ENG-SP18002-PDR-Redlines-V5.pdf Markup Summary

PRELIMINARY DRAINAGE REPORT
FOR
TIMBERIDGE ESTATE, PRELIMINARY PLAN
PART OF THE RETREAT AT TIMBERIDGE
COMMUNITY DEVELOPMENT

## Culvert Crossing at DP 10

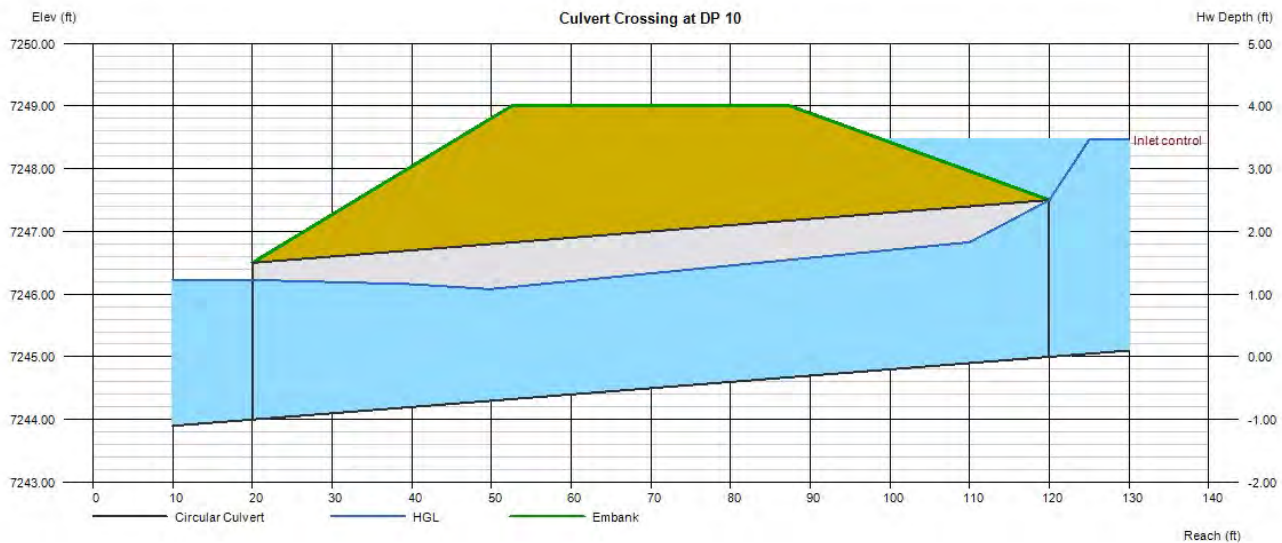
See note at bottom of calculation sheet. Freeboard is entering the culvert, not internal. Discuss size required to meet the 2-foot criteria and if a deviation might be requested at the final plat stage.

The south report provided an analysis of 3-6x16 RCBCs. Discuss options, including what size would be required to meet the 2-foot freeboard requirement (entering the culvert).
